From: Anita Gardner <Anita.Gardner@arun.gov.uk>
Sent: 22 December 2020 14:47
To: Planning.Responses <Planning.Responses@arun.gov.uk>
Subject: FW: WA/87/20/CLE - Stoneybrook Farm, Eastergate Lane

STONEY BROOK FARM
FIRST FLOOR - SOUTH

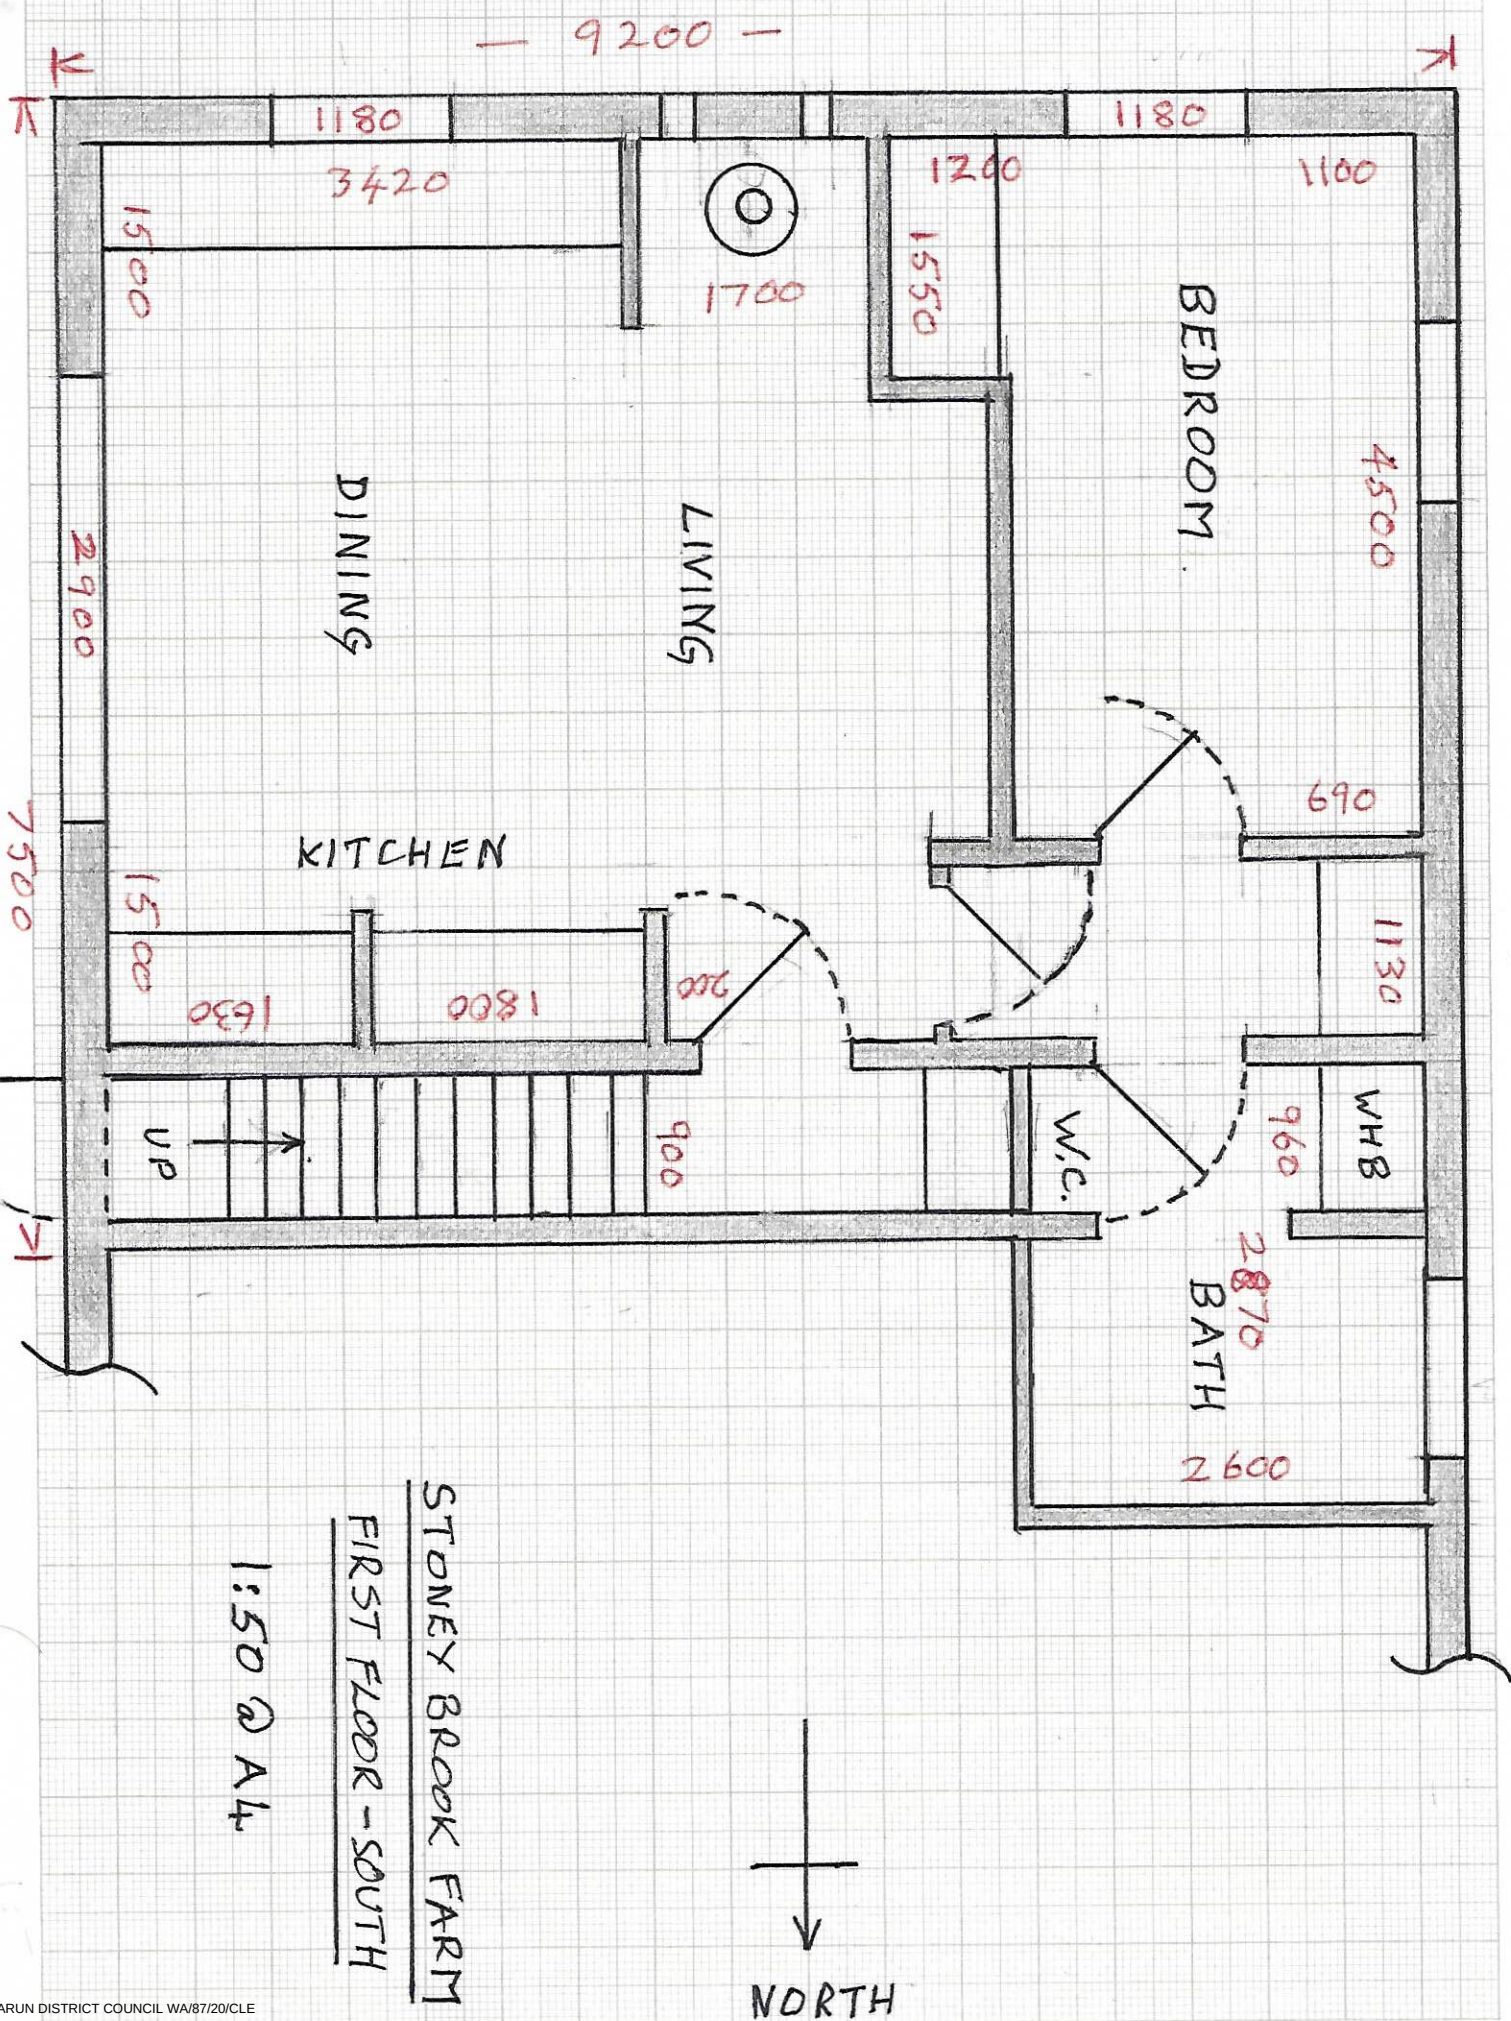
Can you also clarify how access is gained from the ground floor? Should part of ground floor be included as part of the certificate application? A ground floor plan would be useful to clarify.

There is no specific garden or parking area for exclusive use of the flat.
The stairs go direct outside and do not go inside the ground floor of the barn
